Subject: 2025/90047 at location 178, Marsh Lane, Shepley, Huddersfield, HD8 8AY

Please see ecological commentary below:

CLIENT MRS SHEPHERD				
PROJECT 178 MARH LANE, SHEPLEY, HD8 8AY				
DRAWING TITLE GA DRAWING - PROPOSED				
JOB NO WHPR 22/0027	DRG NO 03	REV C	SCALE @ A1 AS	DATE 17 01 23

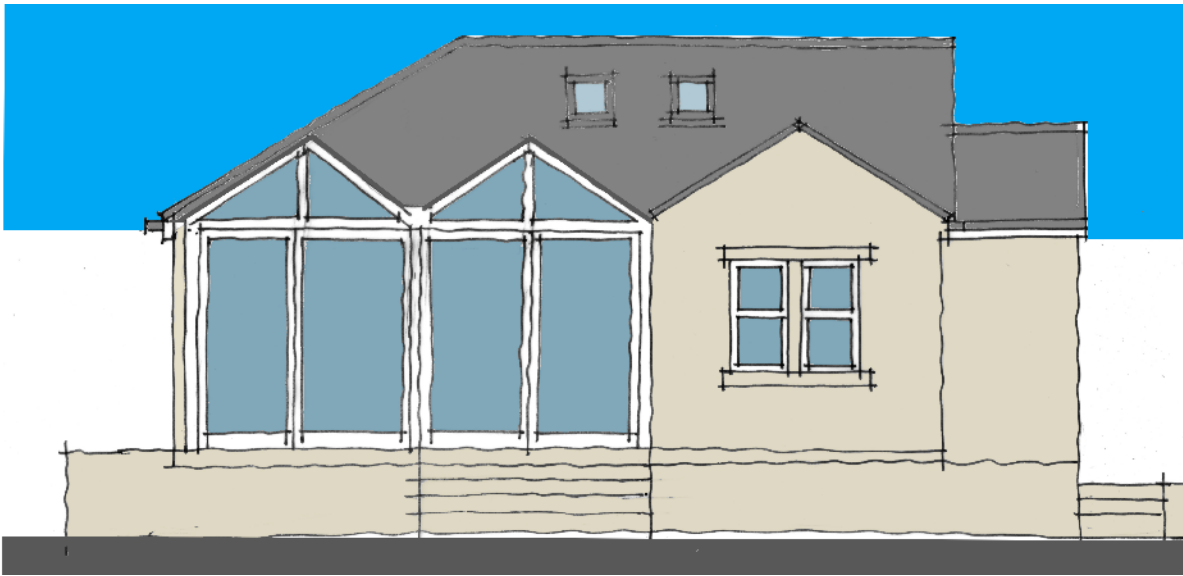
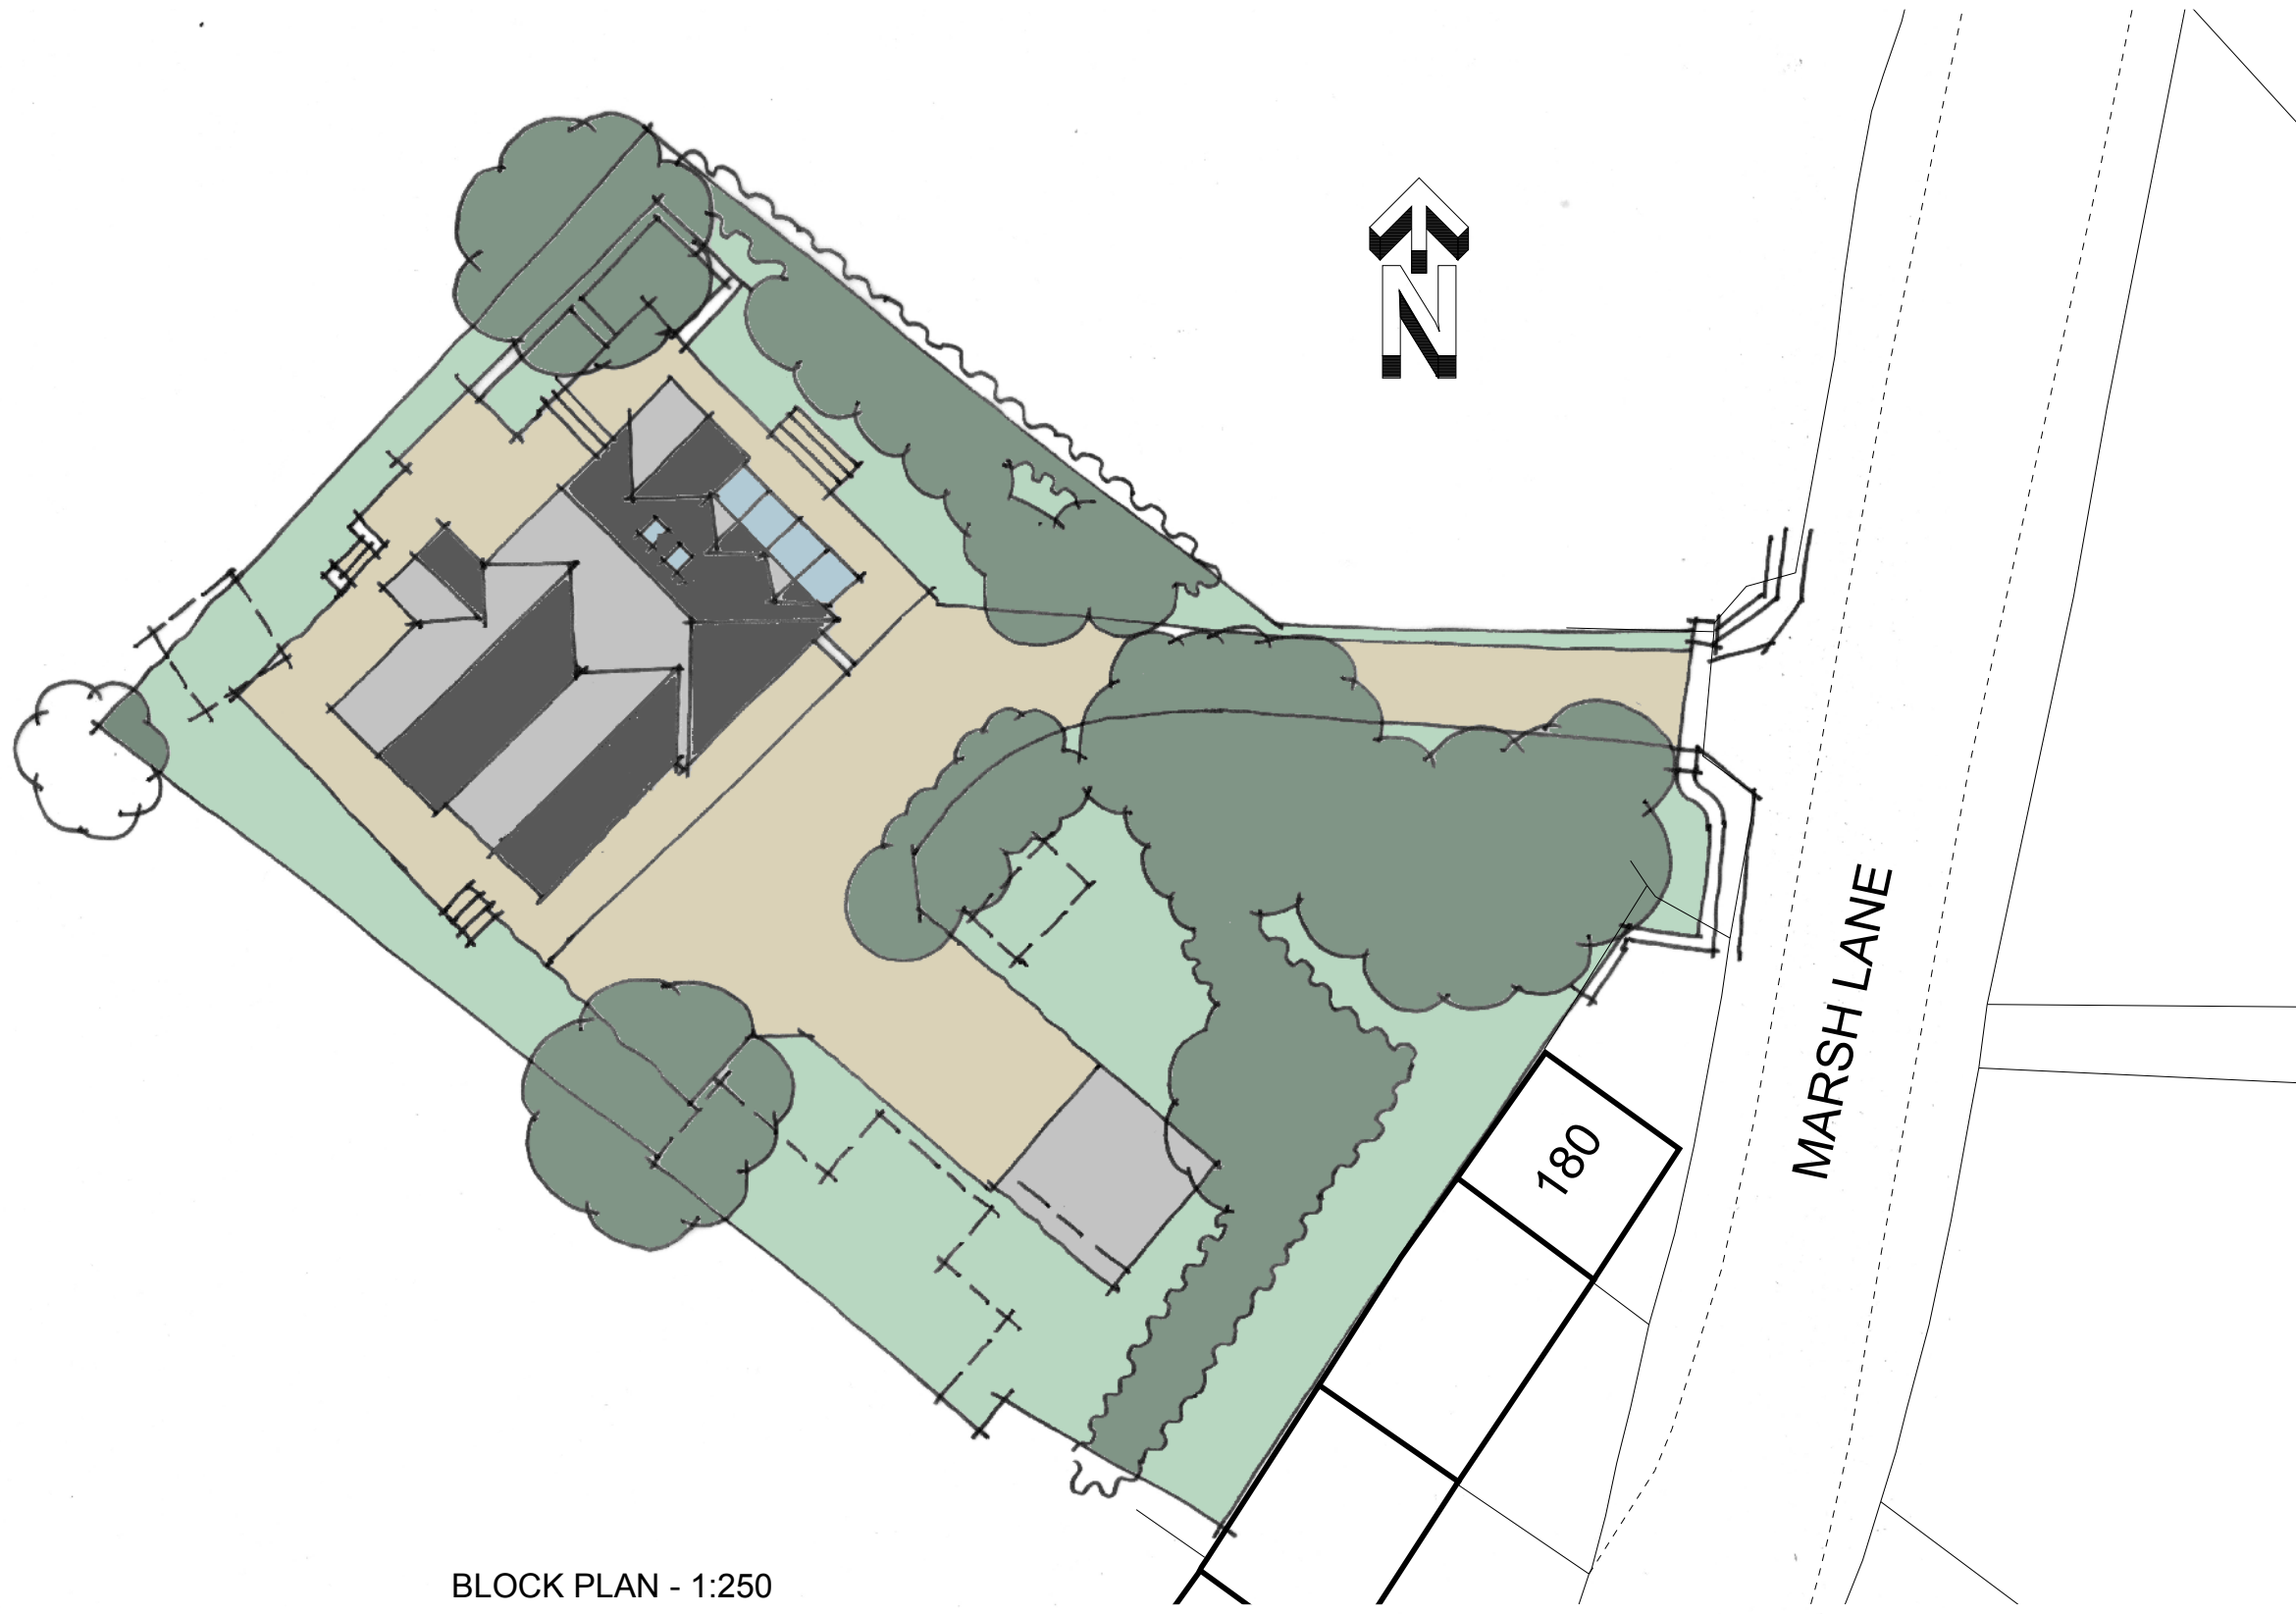
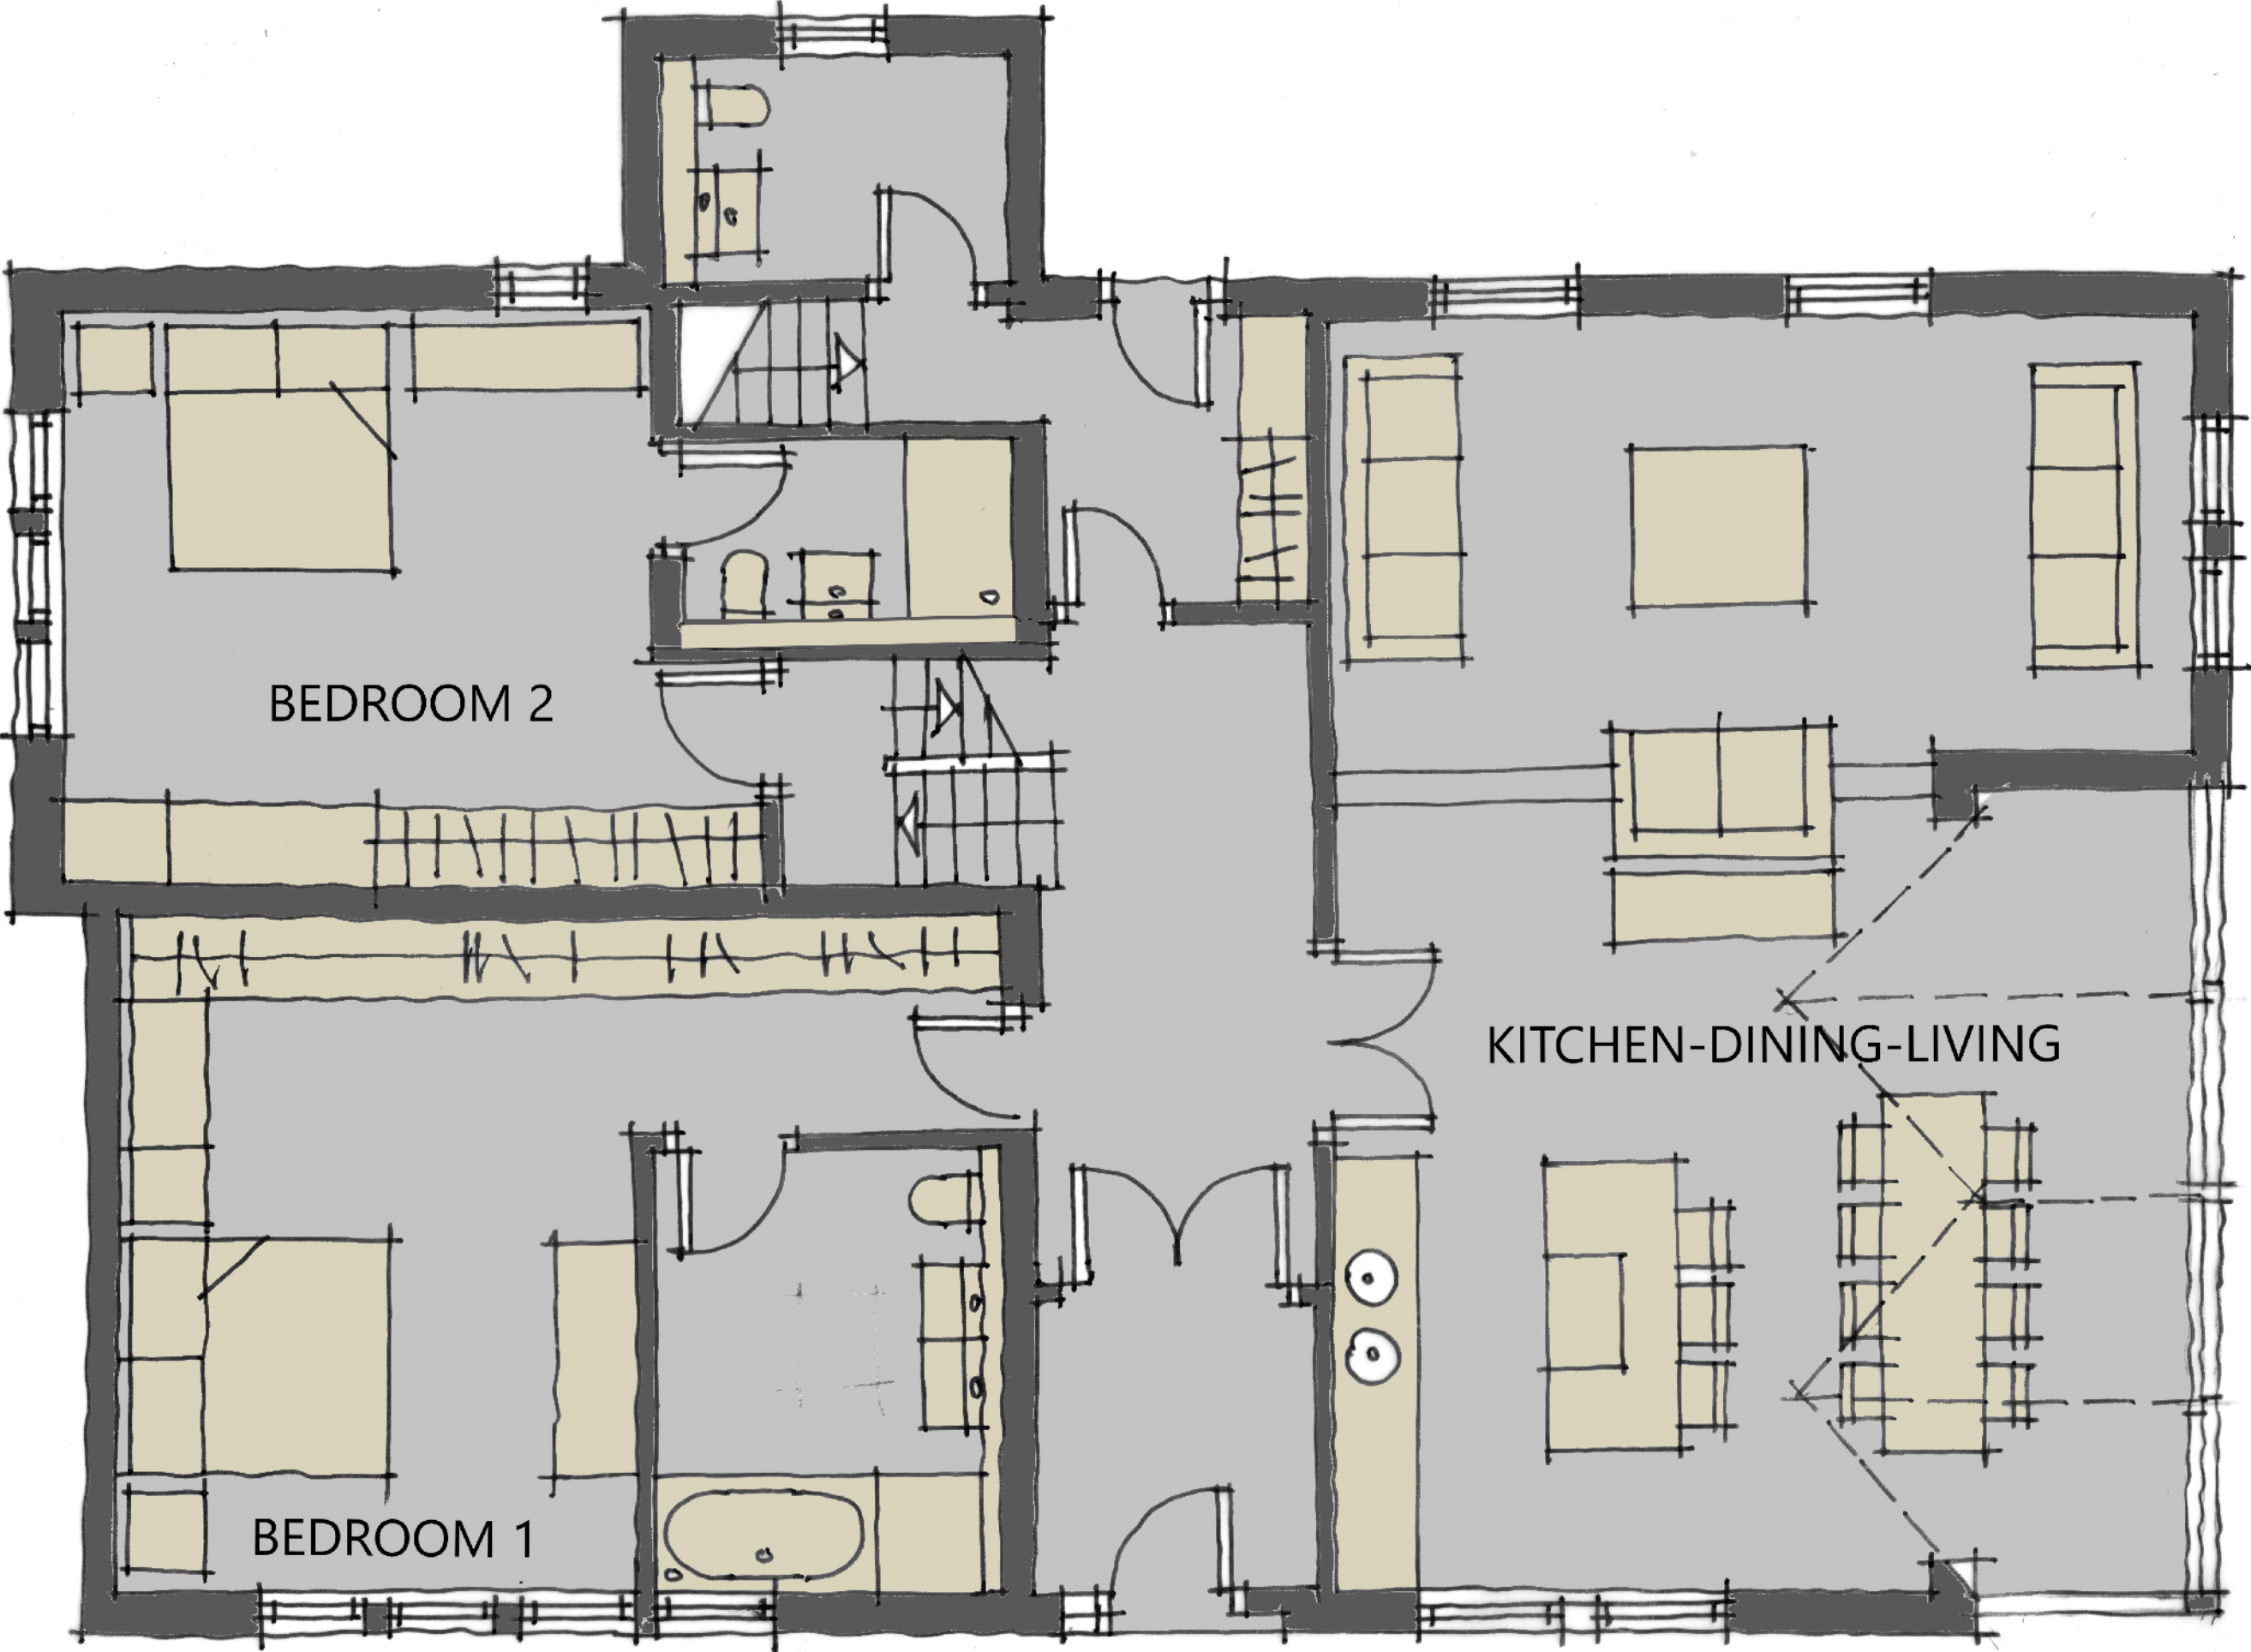
The Preliminary Bat Roost Assessment is reasonable and acceptable. The house was identified as having moderate roosting potential and bat surveys are required to assess whether there are roosts in the buildings. The Bat Survey report provided is reasonable and acceptable. No bats were observed emerging from the House. Precautionary measures are advised, which can be mentioned in an informative. Enhancements are also encouraged with a bat tube on the new building.

- 1 no. integrated bat box
